Designer's Response

Project	23314
Project Number	Wicks Farm Glasshouse and Reservoirs, Ford
Comments Received from	Paul Cann
Date Comments Received	4 May 2021
Date of Response	29 June 2021

TITLE
Proposed Levels and Drainage
Sheet 1 of 6

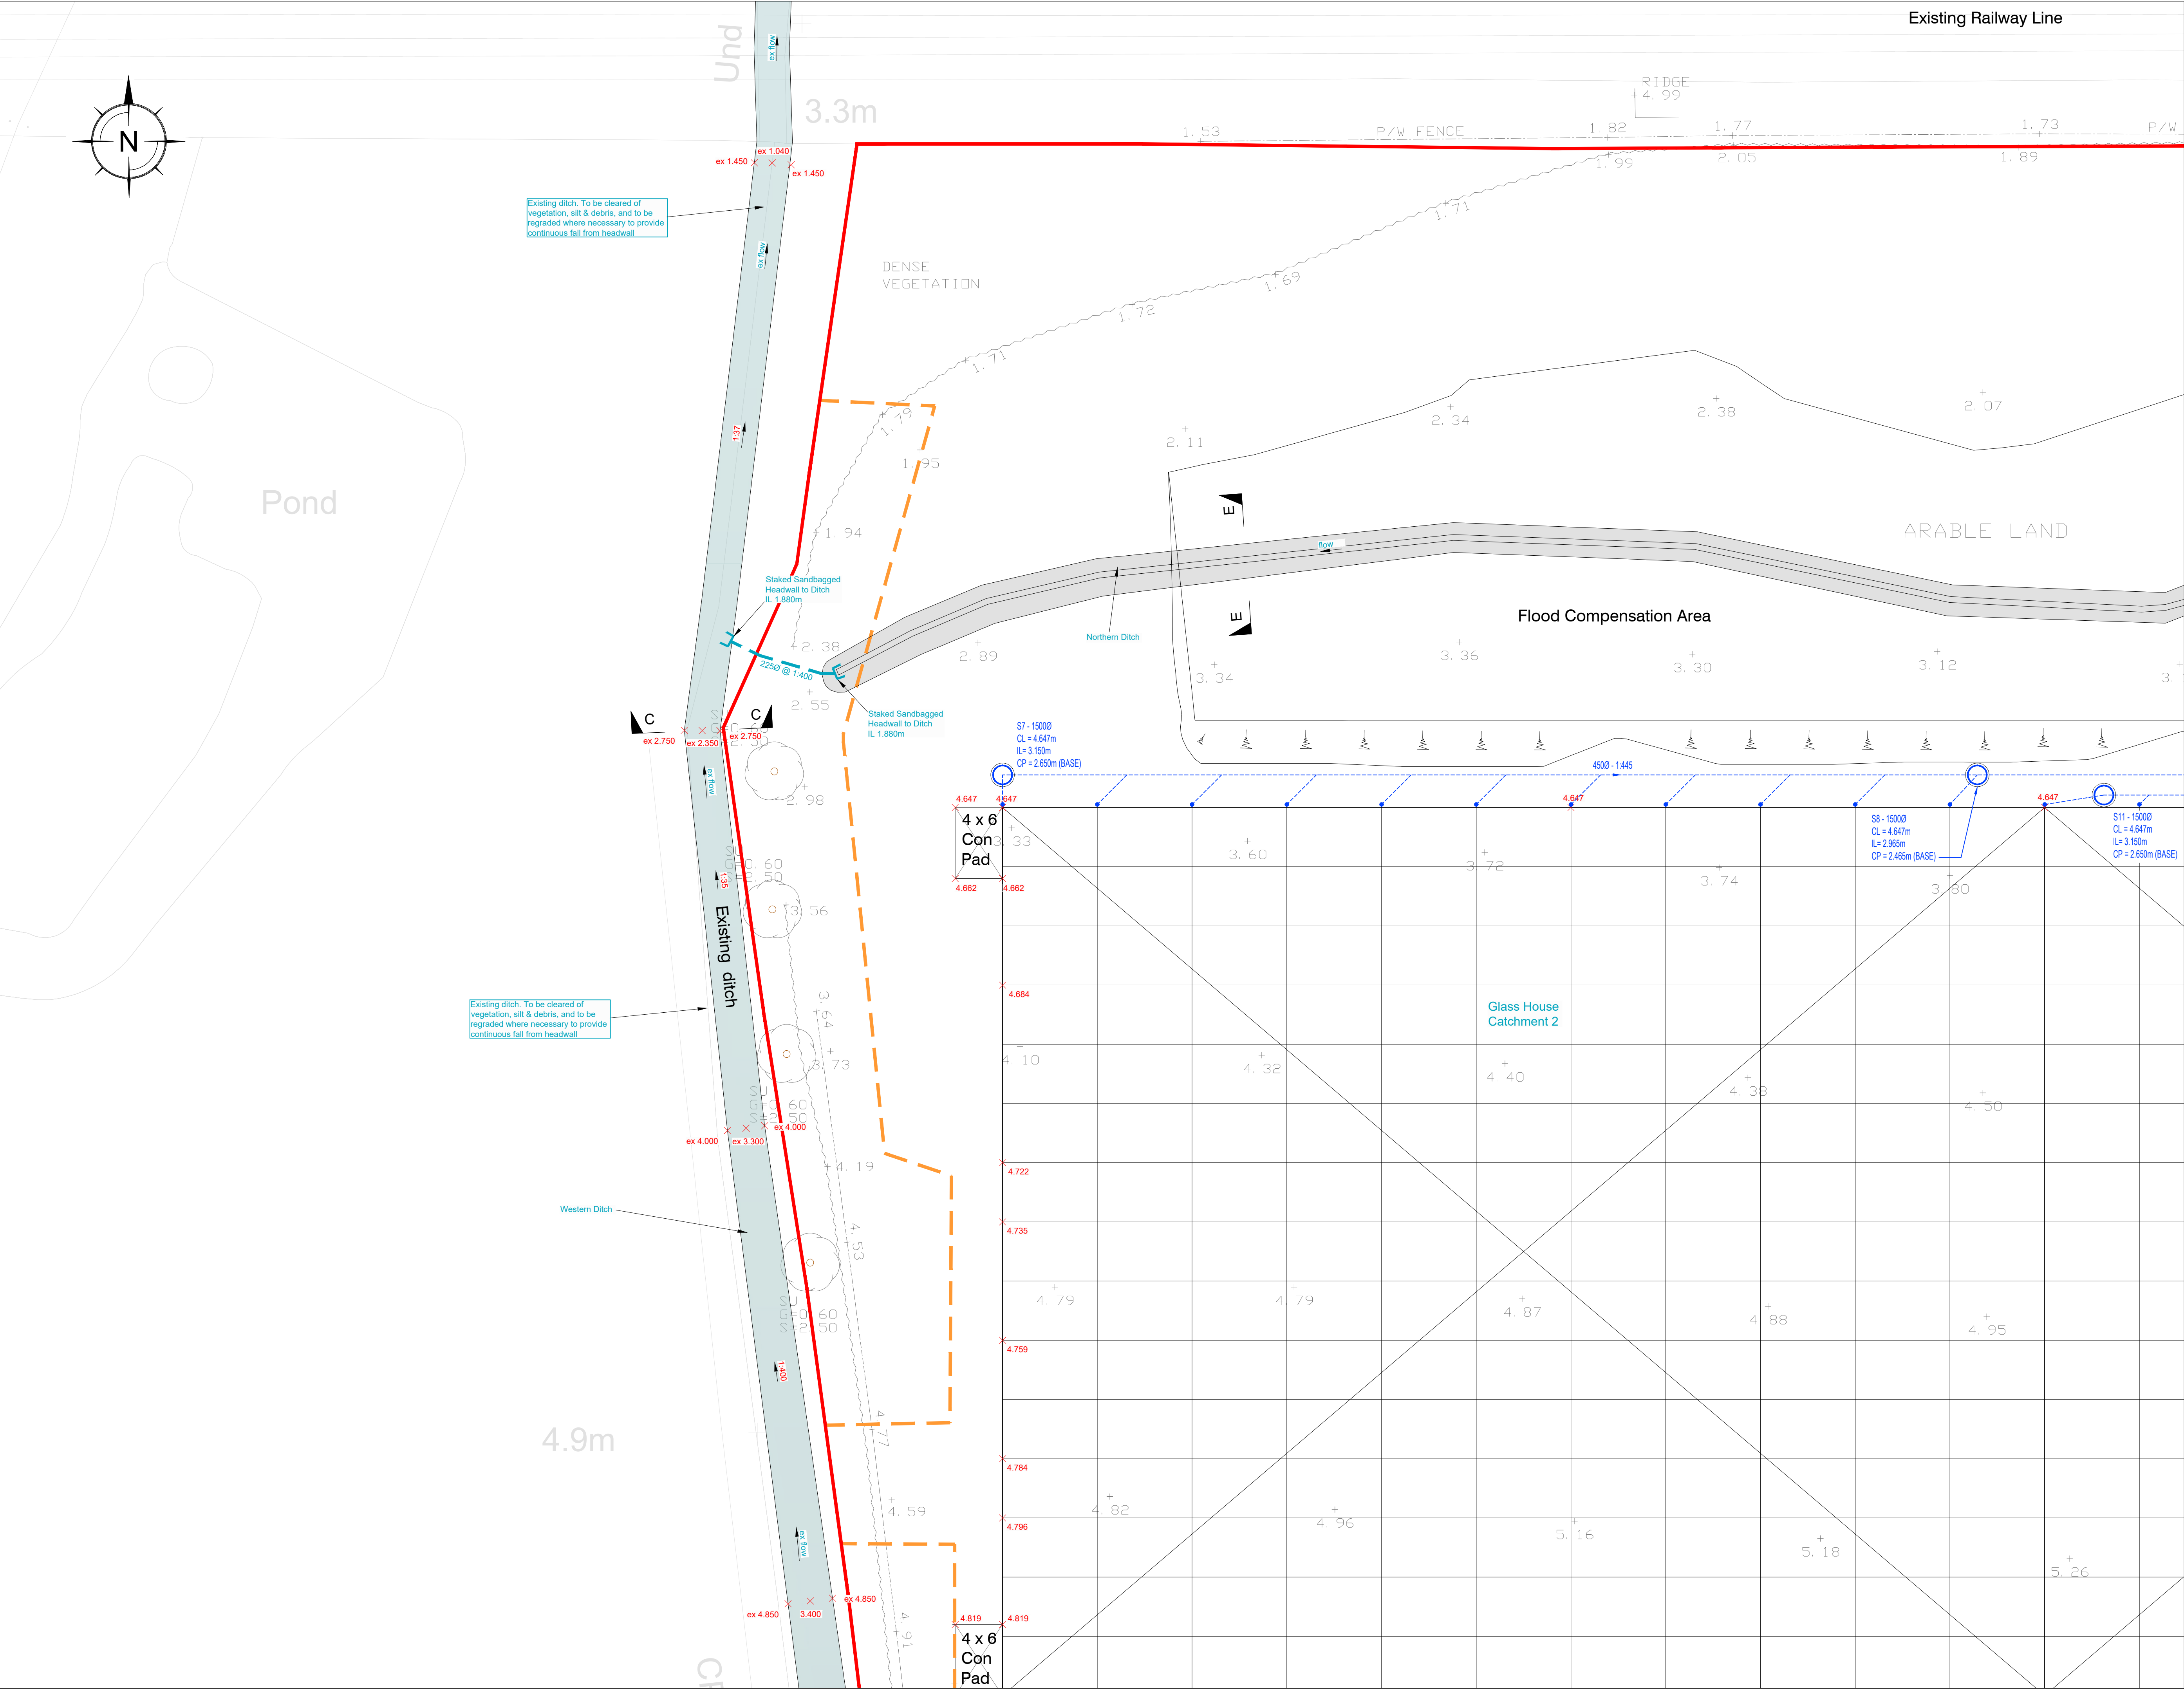
Comment / Query	Designer's response
Western ditch is now piped with 150mm dia pipe in part	This ditch was culverted in error and has now been excavated and the culvert removed.
The outlet to the filter drainage is in one position on the as built info, planning drawing shows multiple outlets.	This refers to the French drain which has been taken to the western swale in a 225mm pipe. Whilst the 225mm pipe may not convey the full 100 year plus climate change rainfall event if the system overtops it will flow overland entirely within the site over the concrete site access roadway and be collected in the swale where it was originally intended to be discharged in multiple locations. There is no risk to any downstream catchment off site from this arrangement. We do not propose any change to this system.
Glasshouse roof water drainage is a different design from the planning. Planning drawing shows a gravity system with spaced out multiple outlets, headwalls and inspection chambers into the reservoir. Installed design is a fully closed system with outlets concentrated in one area.	The roof drainage has been built as a syphonic system, the original gravity system did not take storage in the gravity pipework into account in the storage calculations, all storage was within the reservoir and swales. These pipe sizes were for gravity conveyance only. There is no risk to any downstream catchment off site from this arrangement. We do not propose any change to this system.

Northern ditch is central to the meadow as appose to the planning drawing which details it parallel to the railway track. There are a few minor level difference on other areas but the above points are the headline differences that will need to be looked at for planning and compliance.	Whilst this encroaches into the existing flood storage area, it is not reducing the volume of storage available. There is no risk to any downstream catchment off site from this arrangement. We do not propose any change to this system.

CLIENT	DPS Limited		
PROJECT	Wicks Farm Ford		
TITLE	Proposed Levels and Drainage Sheet 2 of 6		
DRAWN	DATE	PROJECT NO.	
PR	Feb 2020		23314
ENGINEER	CHECKED	DWG. No.	REV.
SB		22	H
SCALE			
1:250 @ A1

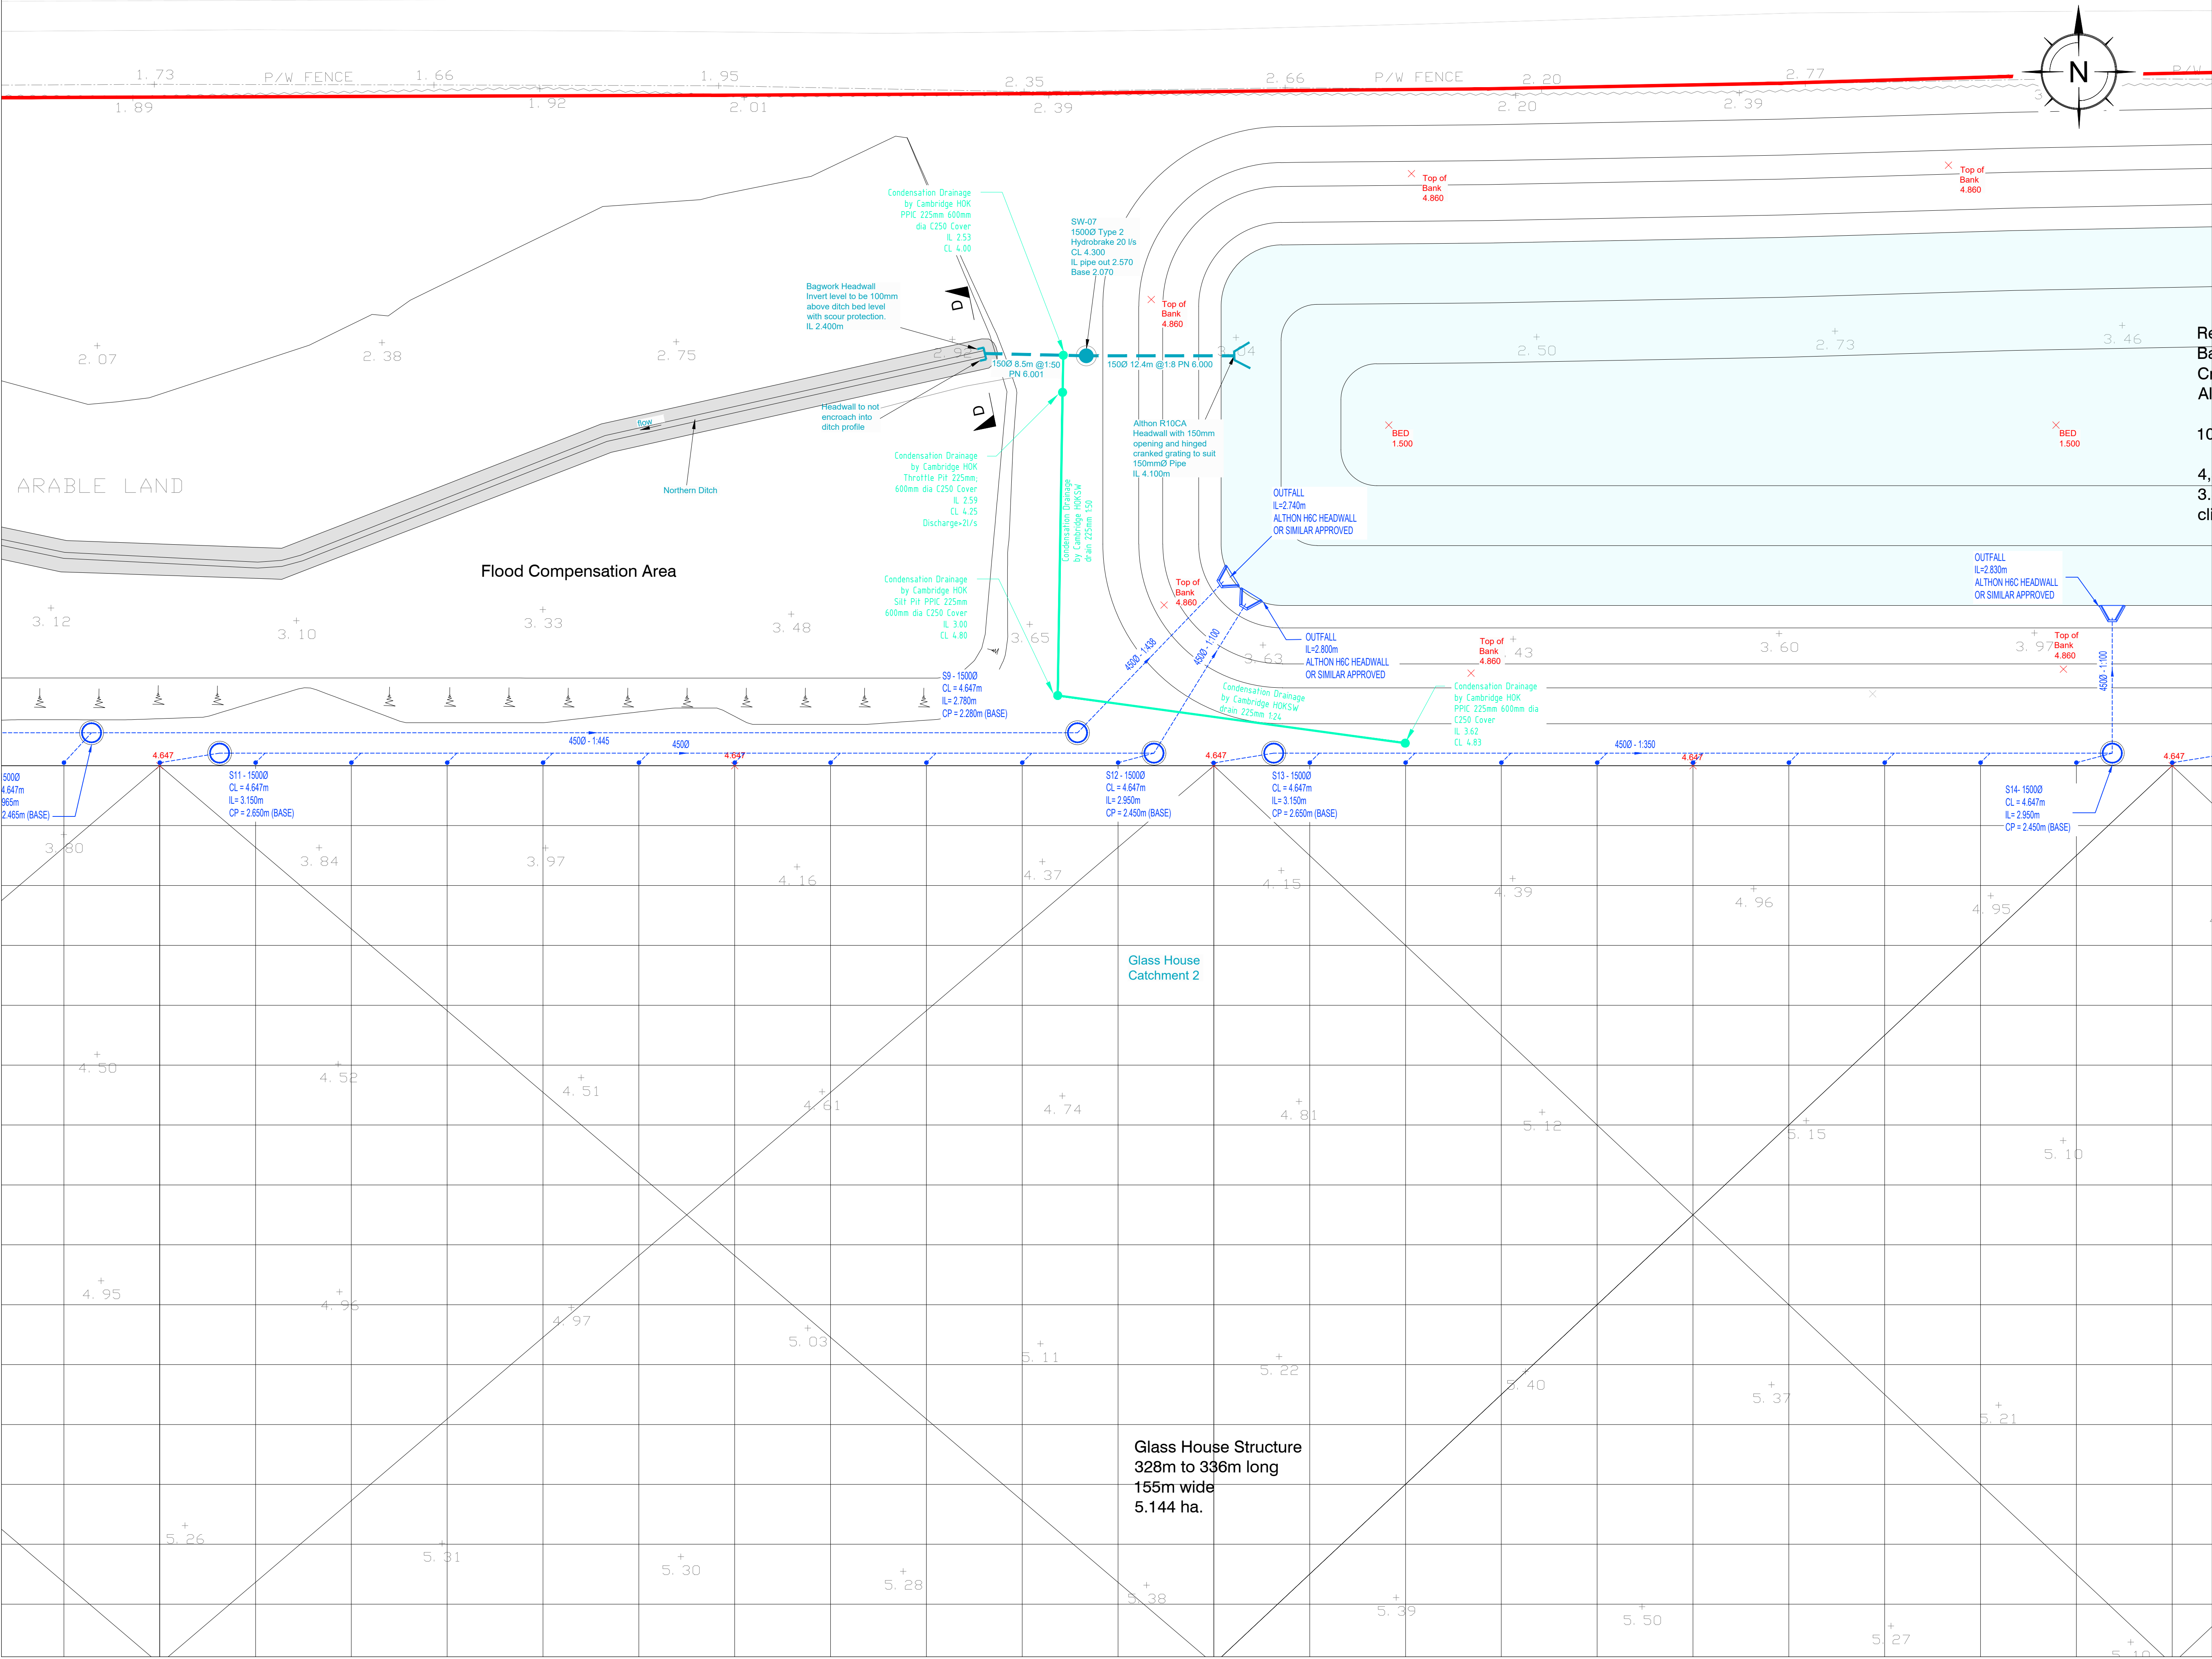
Comment / Query		Designer's response
1	Invert bed planning 1.5, as built 1.52-1.28	Invert levels will not affect storm water storage volume only irrigation water. The base level of the reservoir has been sloped to aid periodic cleaning and taken as a whole does not reduce the required design storm storage volume. We do not propose to make any alterations to this element.
2	Reservoir Crest Level, planning granted at 4.86m AOD, as built indicated 5.11-5.17m AOD on the north bank and 4.70-4.88 m AOD on the south Bank	Crest heights higher than designed on the north side of the reservoir and lower than designed (by 160mm) on the south side of the reservoir. This will negatively affect available storm water storage volume above the required irrigation water and is not as per the design. The level of the south bank of the reservoir will be raised to a minimum of 4.86m AOD to ensure the design storage volume is provided in the reservoir. The north bank can remain, but this could be lowered to 4.86m AOD to utilise the excess fill material.

Comment / Query	Designer's response
3 Reservoir Outlet pipe level, planning granted at 3.850m AOD, as built level is 4.100m AOD.	This reduces the available storm water storage volume above required irrigation water by 250mm across the reservoir. We propose that a second outlet to the hydrobrake manhole is constructed at 3.85m AOD and the current outlet is removed.
4 Reservoir Hydro brake, planning granted for a discharge at 20/l/s, as built hydrobrake restricted to 13/l/s.	This is a reduction below greenfield runoff and will also affect the requirement for storm water storage the requirement for which will have been increased as a result. We propose the hydrobrake is changed to the planning agreed model with an outlet of 20l/s.
Swale inter connections as pointed out on site are different, installed 1 x 450mm, Planning 2 x 600mm. Originally there were far more yard concrete planned and is currently still shown on the planning drawings. The as built surface area run off to the front of the site is far less so therefore water flow through the ditch and swales reduces significantly.	This refers to the storage swale at the southwest side of the site. A reduction from 2x600mm to a single 450mm pipe is considerable. We propose that the 450mm pipe is replaced with the planning approved twin 600mm pipes or that 3 additional 450mm pipes are added to the existing 450mm pipe to allow the same conveyance.

Main swale, Bed level planning 4.100-3.800, as built 4.125	This will have resulted in reduced storage available within the swale and should be rectified. We propose the base of the swale is adjusted to the planning levels.
Outlet from main southern swale, planning 3.750, as built 3.980. Also pipe size on the planning drawing 450mm, as built 150mm	The change in invert level constitutes a reduction of available storm water storage volume above required irrigation water by 230mm across the swale. The outlet is governed to 13l/s and the 150mm pipe will allow a conveyance at 1:150 of 14.4l/s. We proposed that the outlet is lowered to the correct level of 3.75m AOD. The 150mm pipe is acceptable and will not affect the discharge to the watercourse.
